From: Amanda Scholes on behalf of Planning.Responses
Sent: 22 May 2020 09:02
To: Planning Scanning
Subject: FW: BR/58/20/PL

To change the approved plans for minor amendments to include changes to internal layouts to plots 2 and 5 to create study room at first floor, general minor internal layout changes to all plots and move position of windows.

From: Maria Tomalova [REDACTED]
Sent: 30 April 2020 13:38
To: [REDACTED]
Subject: BR/58/20/PL

Preparing the approval for the variation of condition I have realized that what you propose would change the description of the original application: 'Demolition of existing building and erection of 6No. dwellings, 2x 3 bedroom and 4x 2 bedroom with associated access and car parking.'
The result of variation is 4x3 2x2, practically acceptable but from the legal point of view not.
I was trying hard to find a solution and consulting our Legal if there is some discretion.

Title:-
Proposed Floor Plans & Elevations (P5&P6)

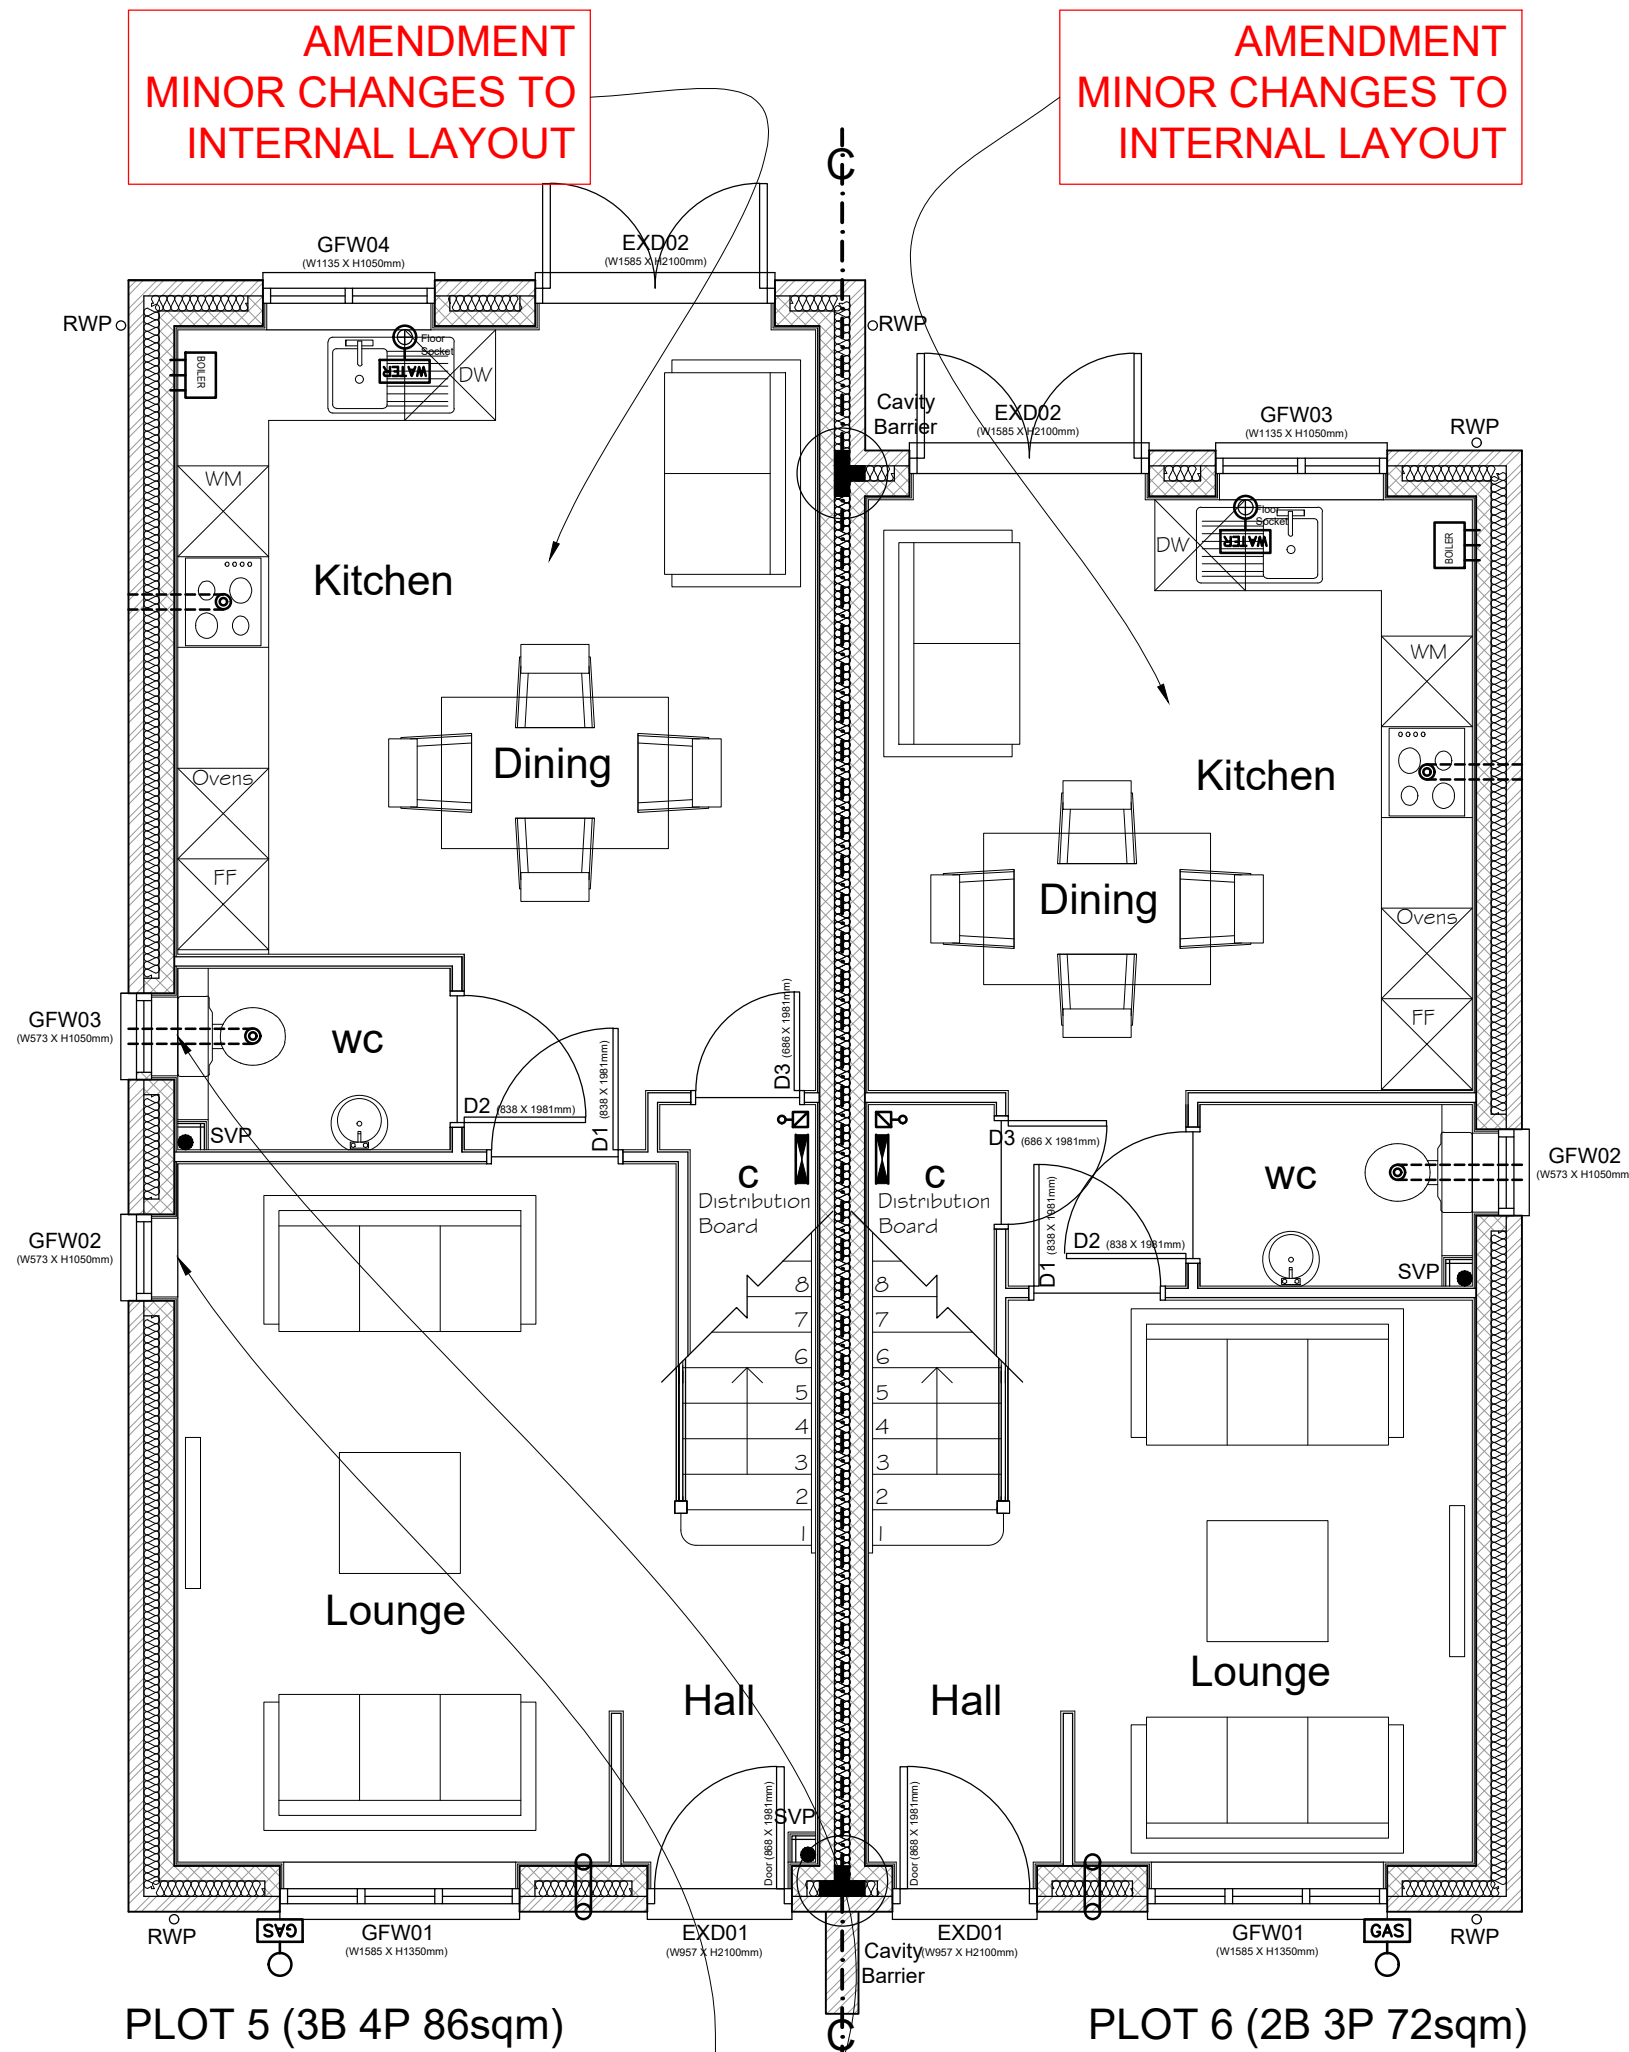
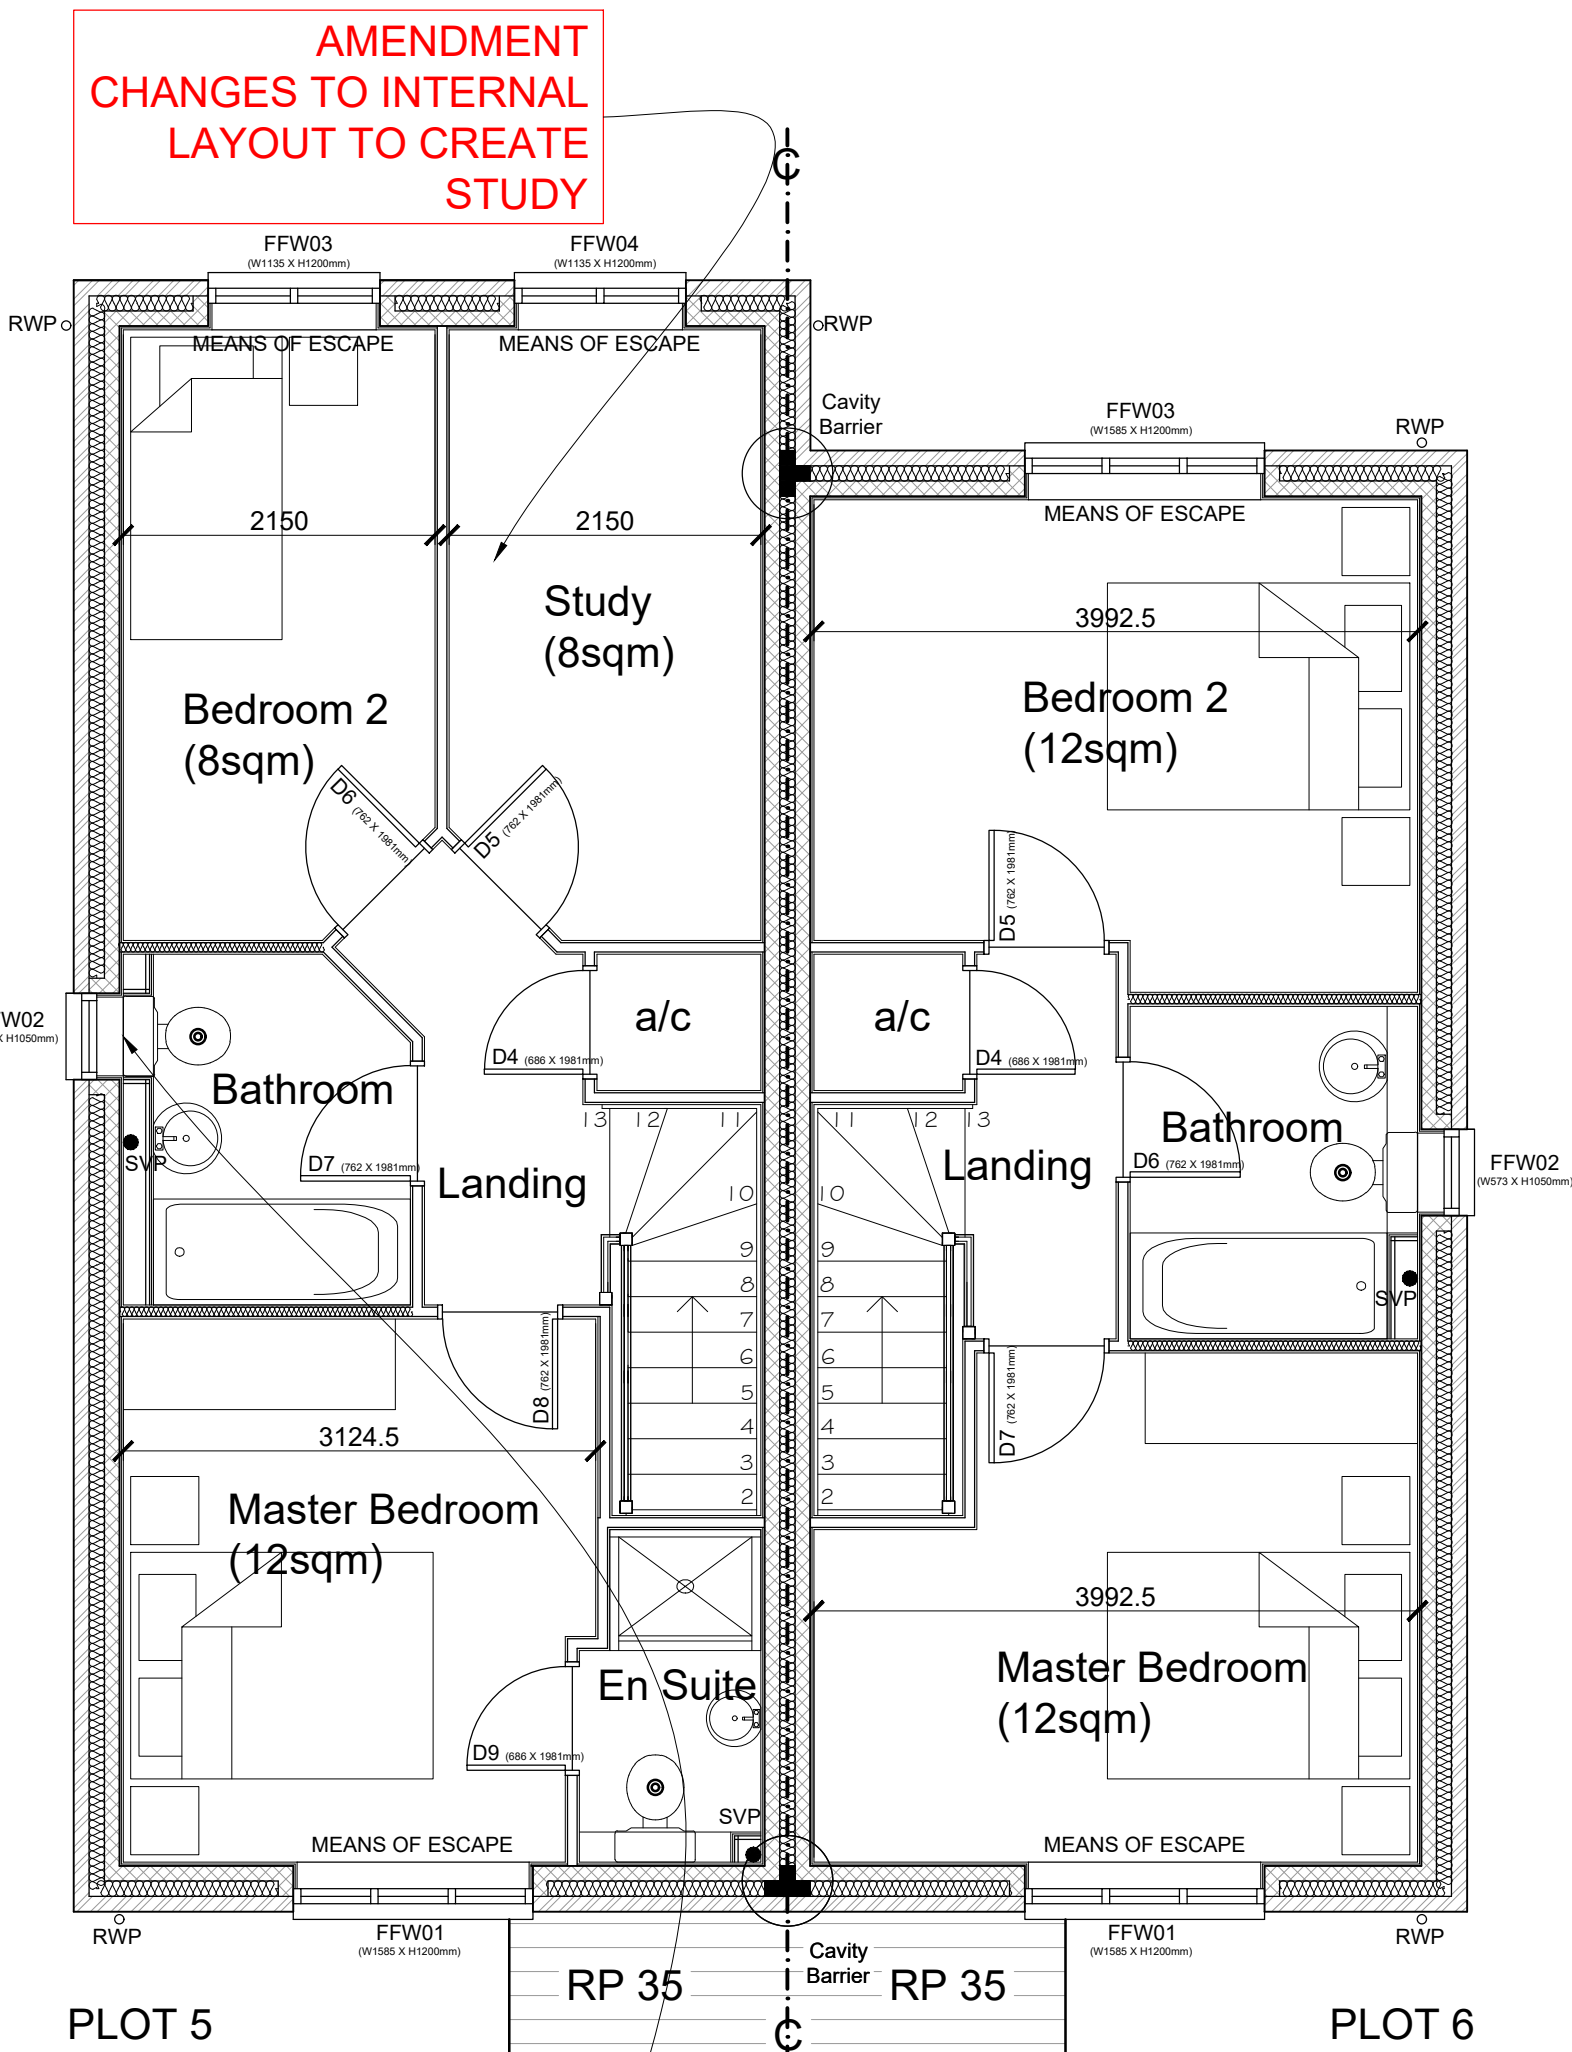
We can accept the above application under section 73 if you sow the third rooms within units 2 and 5 as a study. It is because units at plots 2 and 5 to be 3bed 4 people with internal space requirement 84sqm whilst 81sqm provided (3sqm shortfall), however the number of future occupiers is the same; 4 people. The size of every bedroom is according the requirement within the NDSS.

Just an idea. I understand the issue that a section 73 cannot change the description so we are pretty stuck on this one. However to keep the description of the application the same can we simply call bed 3 a study on the drawings for the 2 units that are the 2 beds therefore it shows a room but it is still a 2 bed unit with a study?

Got your message. Attached revised drawings for plot 2 and 5 showing the study. Hopefully you can now approve the application. Just to note when you are issuing the decision notice can you make sure it is worded so as not to have to discharge any more conditions. We have already got discharge of conditions on the previous consent so these should follow over as performance conditions in accordance with the information already submitted. I don't want to have to submit another discharge of condition application for any new conditions.
